Simon Truong - RE: Re: FW: Block 4S Queries

From: "Alex Sicari" <Alex.Sicari@frasersproperty.com.au>
To: "Simon Truong" <Simon.Truong@planning.nsw.gov.au>, "Gordon Kirkby" <GKirkby@jbaplanning.com.au>
Date: 4/09/2013 8:54 PM
Subject: RE: Re: FW: Block 4S Queries
CC: "Ben Lusher" <Ben.Lusher@planning.nsw.gov.au>, "Mark Brown" <Mark.Brown@planning.nsw.gov.au>, "Michael Goldrick" <Michael.Goldrick@frasersproperty.com.au>, <rpalmer@fosterandpartners.com>, <EKirkman@jbaplanning.com.au>, <trevorhamilton@nettletontribe.com.au>
Attachments: 130904 - B4S GFA sk117-sk132 (clarification provided to DPI) pt 1.pdf

Subject: Block 4S Queries

NOT FOR CONSTRUCTION

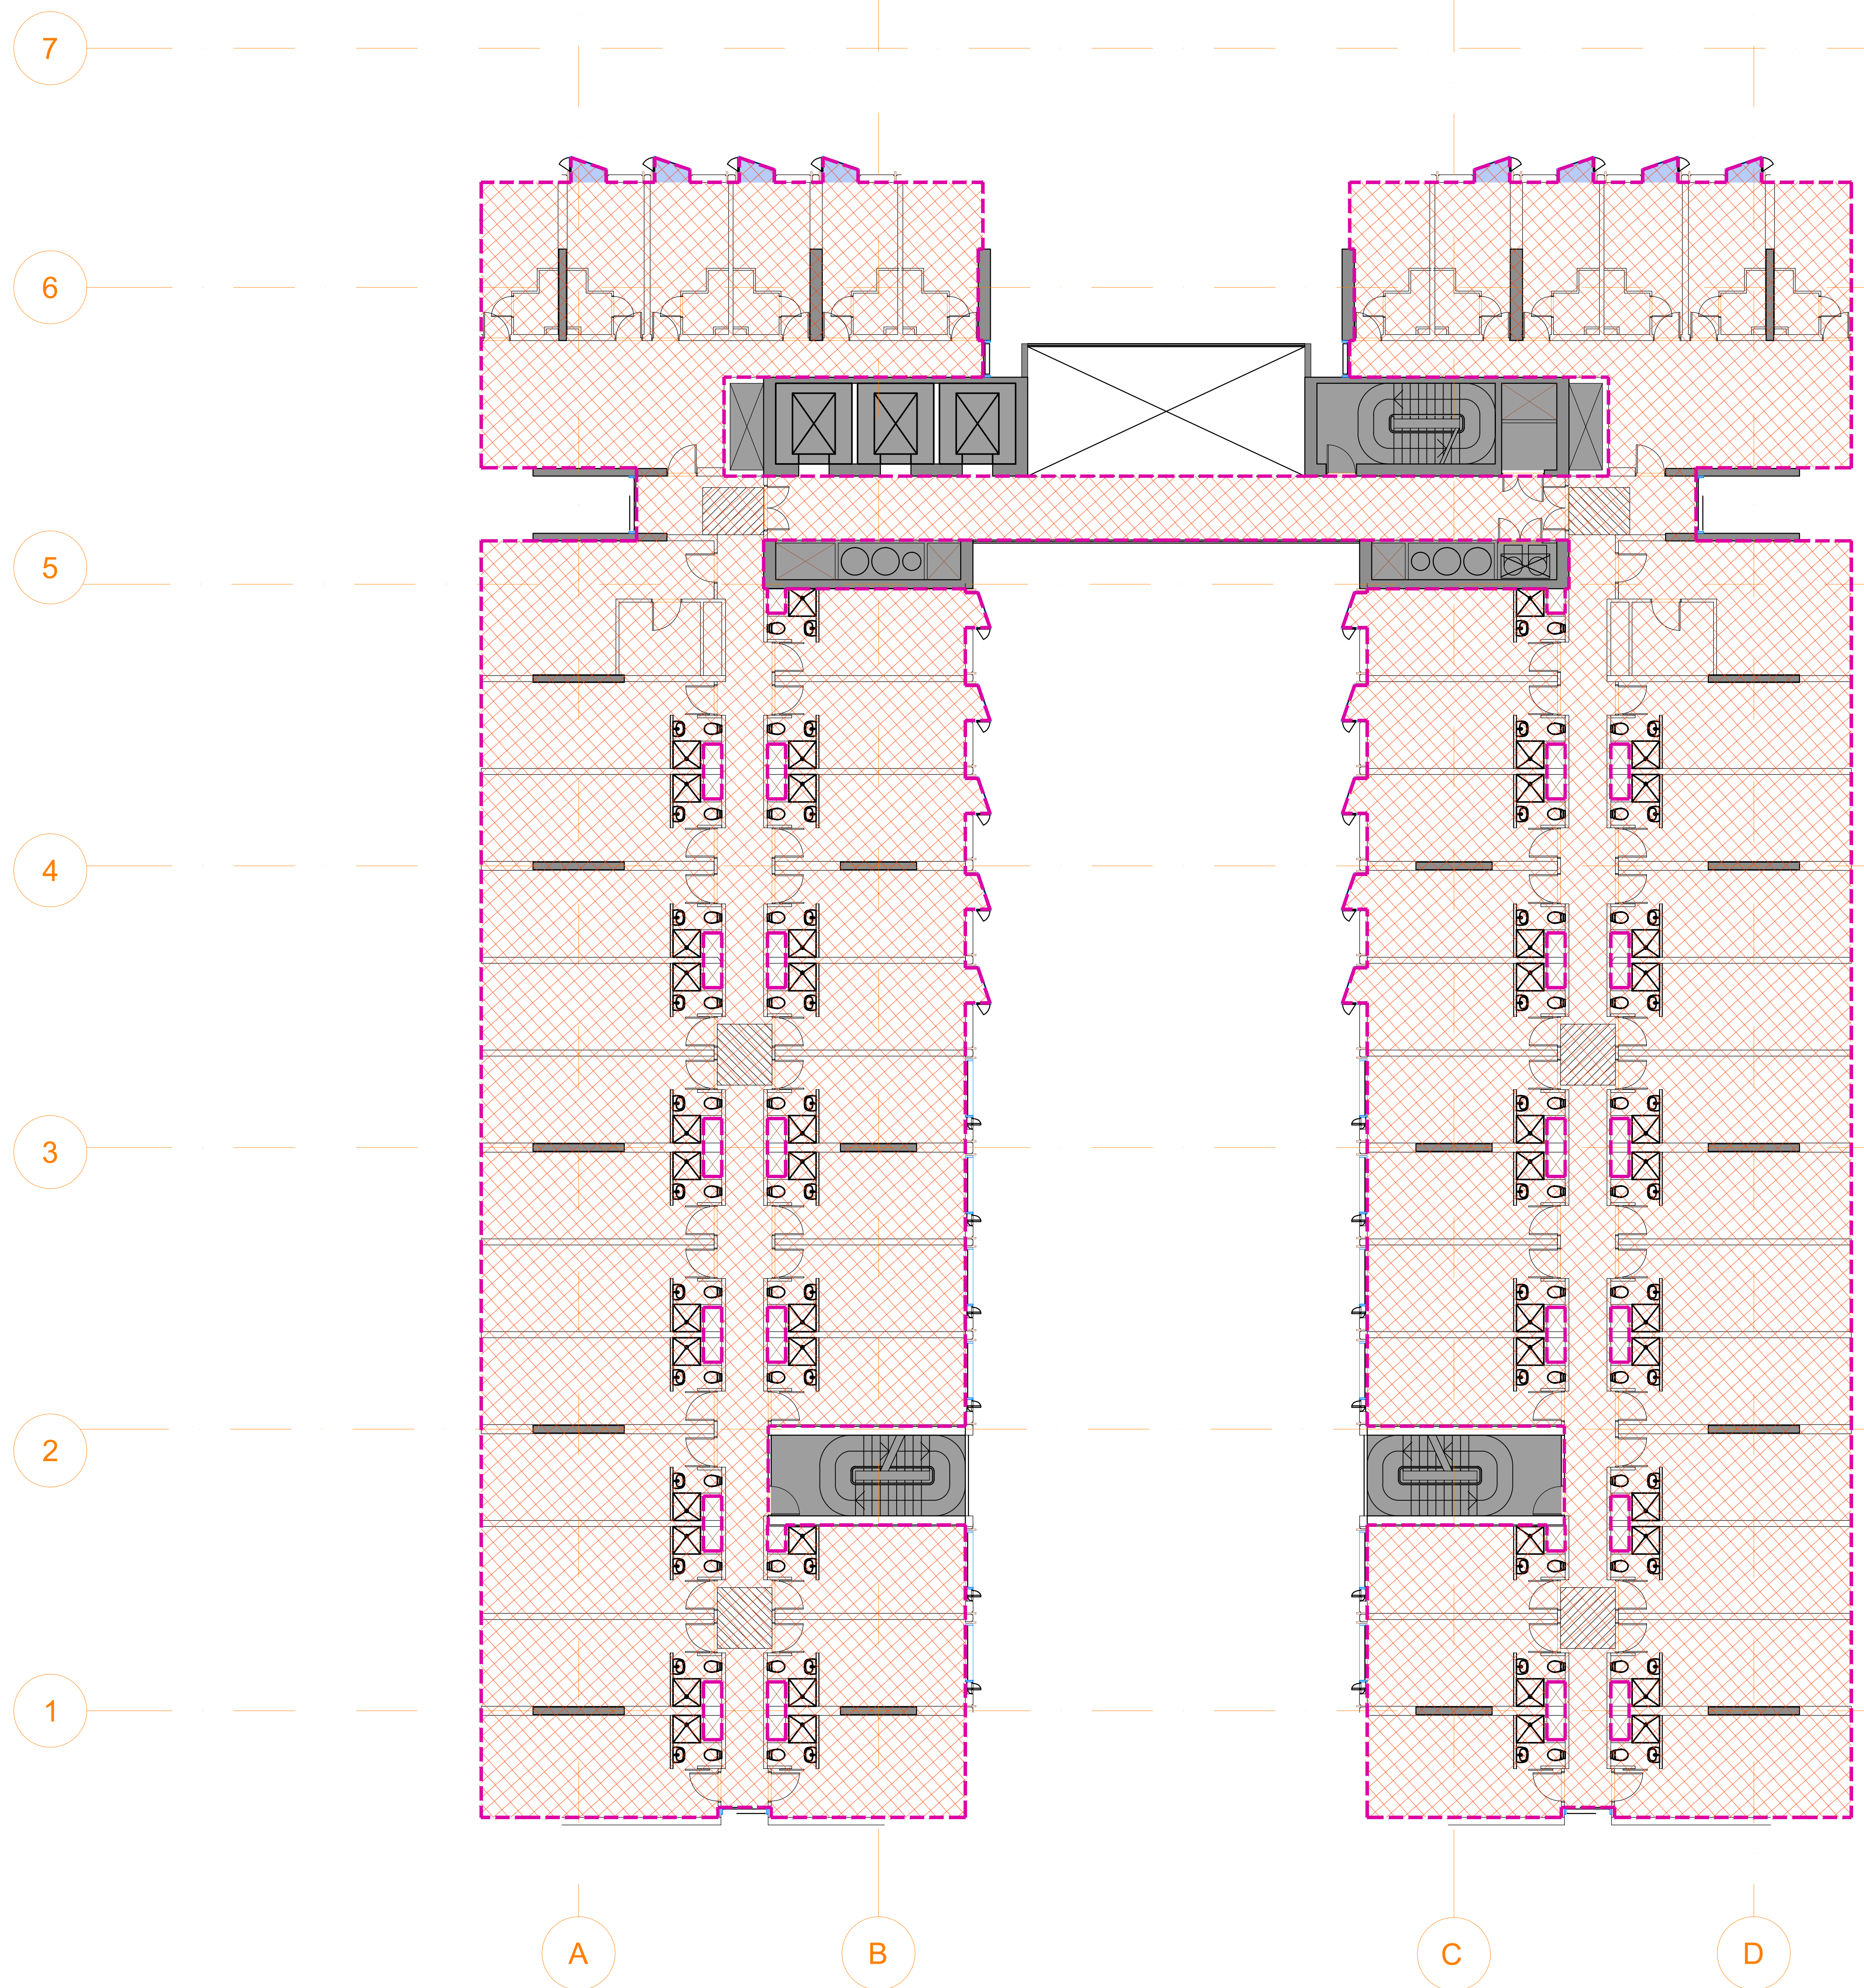
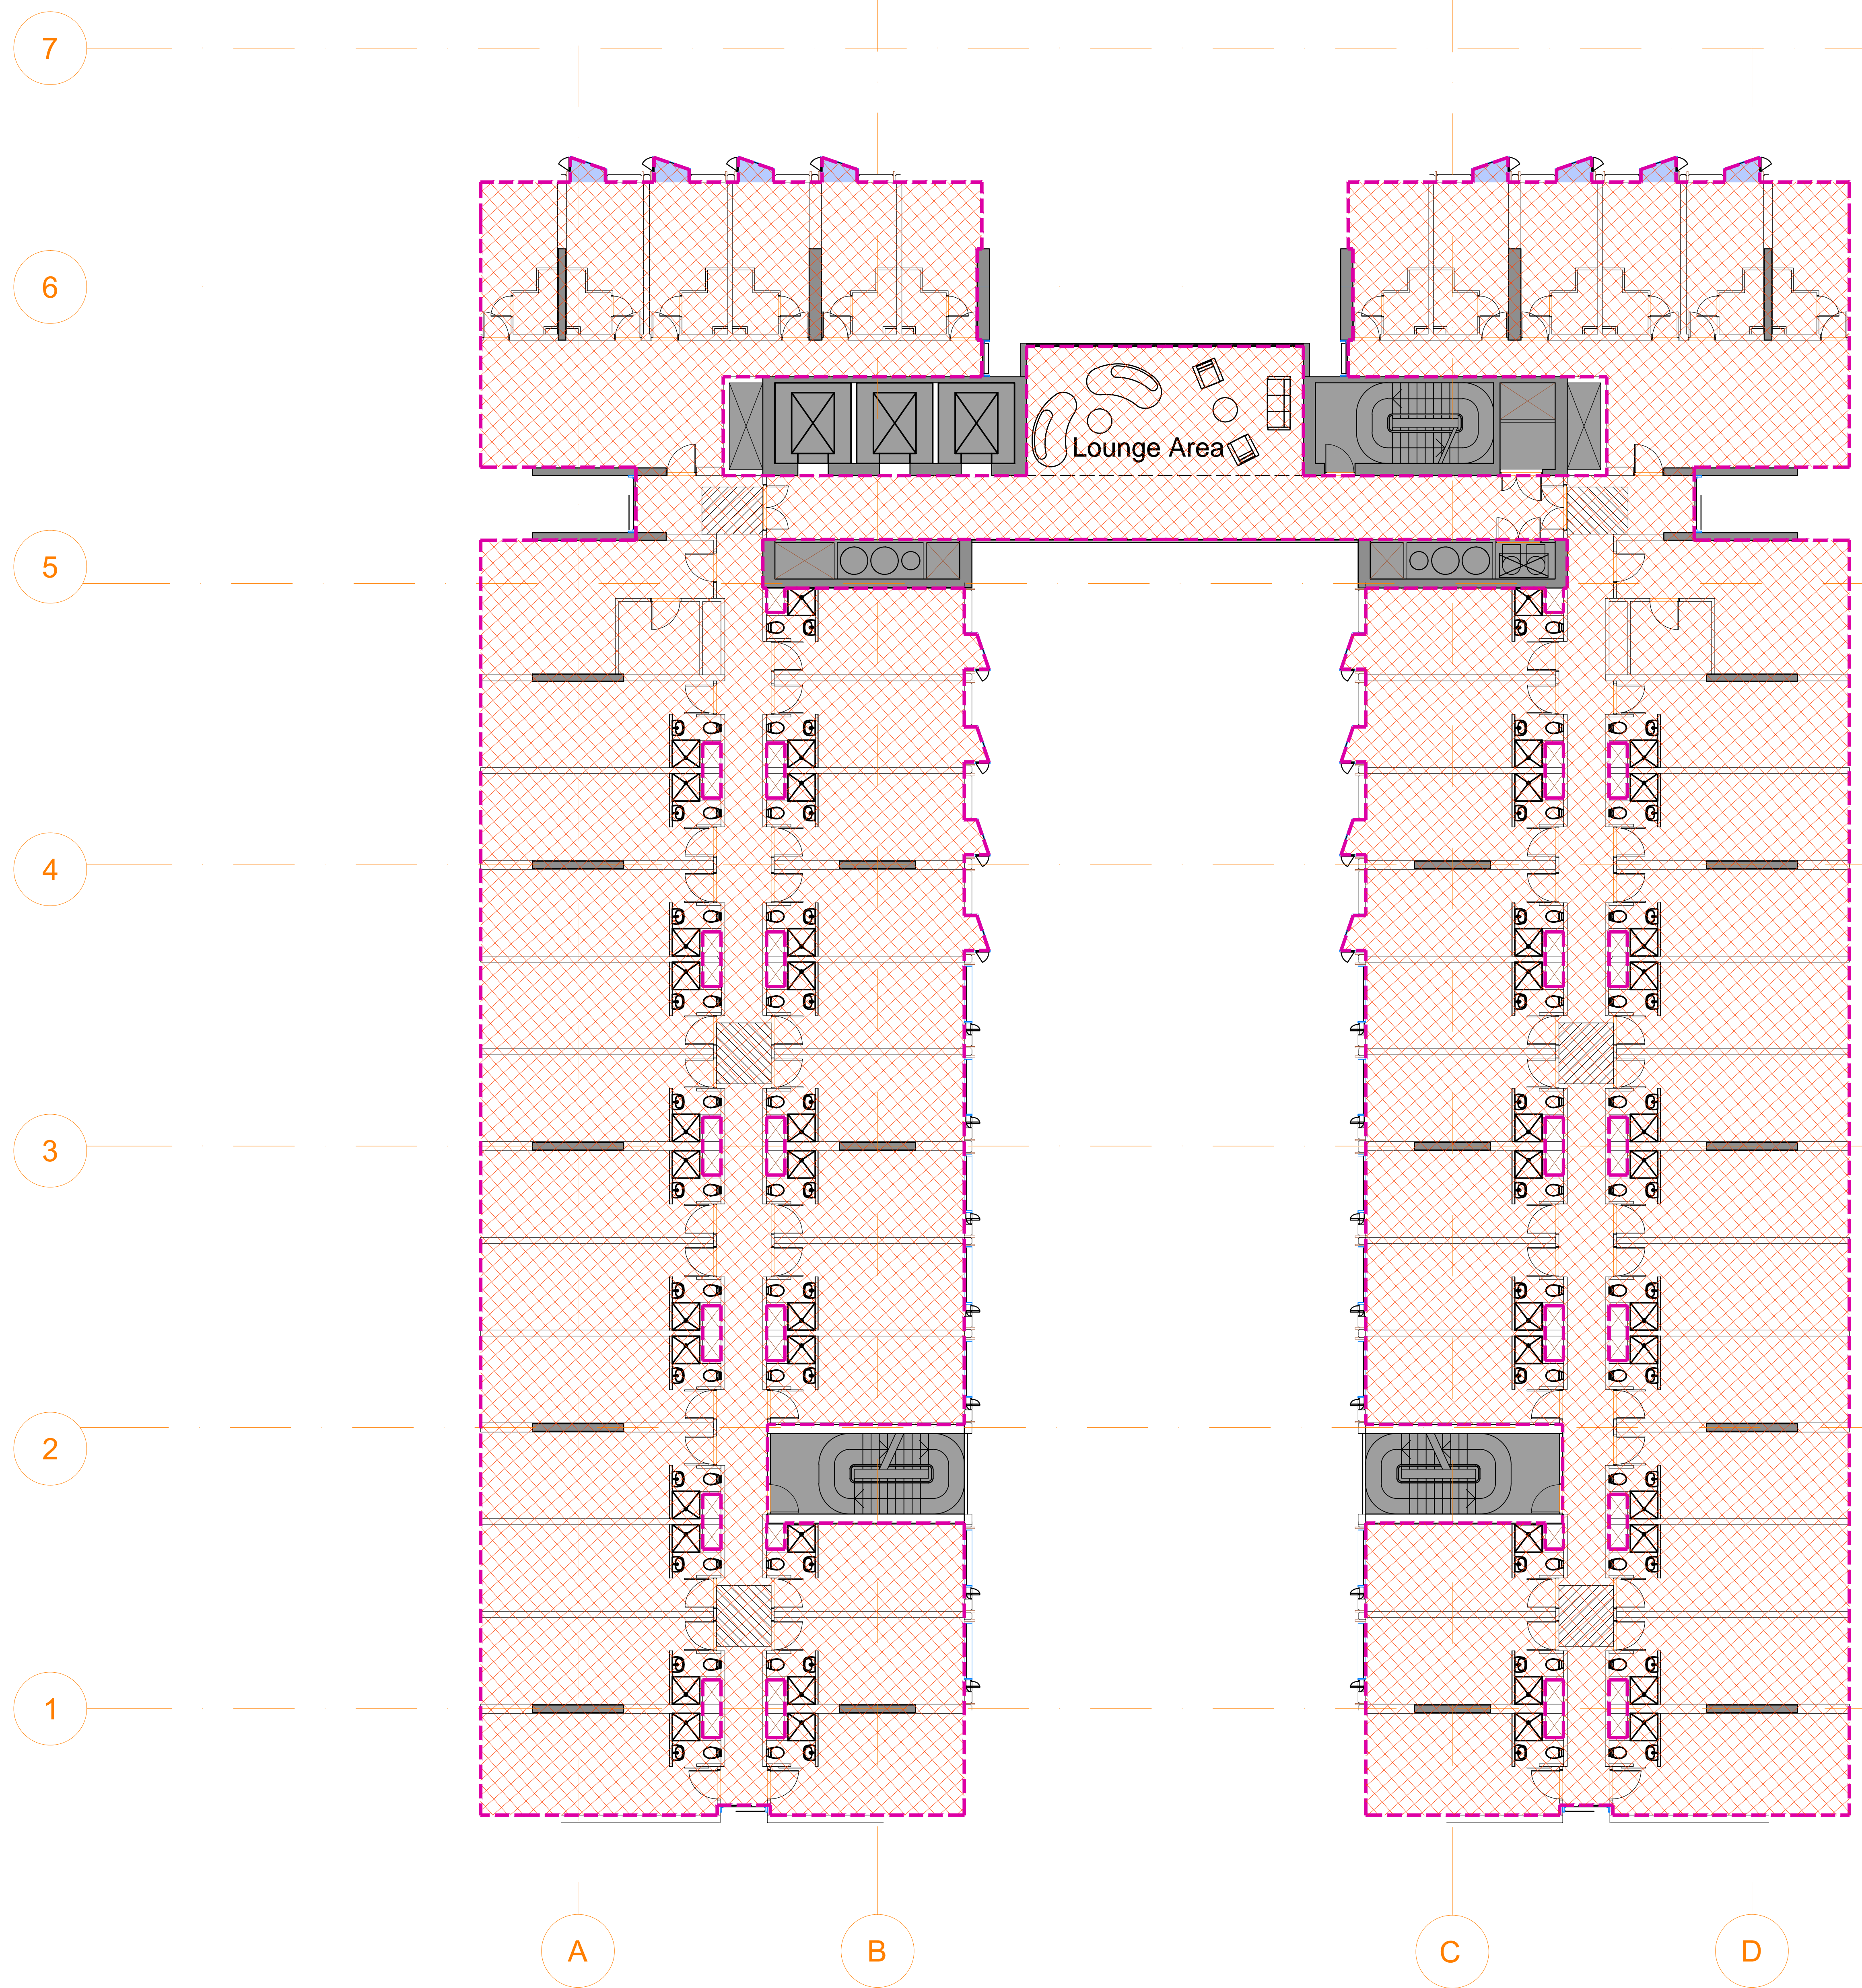
The area schedule on drawing 5013[4] as submitted with the SSDA confuses GFA, NLA, and external area. It does not measure Residential vs Non-Residential GFA.

I note the proposed GFA for Block 4S, however the Department's query relates to the GFA numbers provided.

Can you please clarify?

Modified Concept Plan	Proposal
Residential GFA	23,500m ²	20,991m ²
Non-residential GFA	1,000m ²	901m ²
Total GFA/FSR	24,500m ²	23,813m² (1,921m² unaccounted for)

Residential GFA	22,709.1m2
Non-Residential GFA	1,423.2m2
Total	24,132.3m2

See schedule and GFA-highlighted plans in attachment pt 1 of 2 (due to file size, we will send pt 2 of 2 in a subsequent email)

The difference between the GFA as shown on drawing 5013[4] and the attached is that the bay windows were excluded from the previous measure. We have now corrected this to include for the bay window GFA.
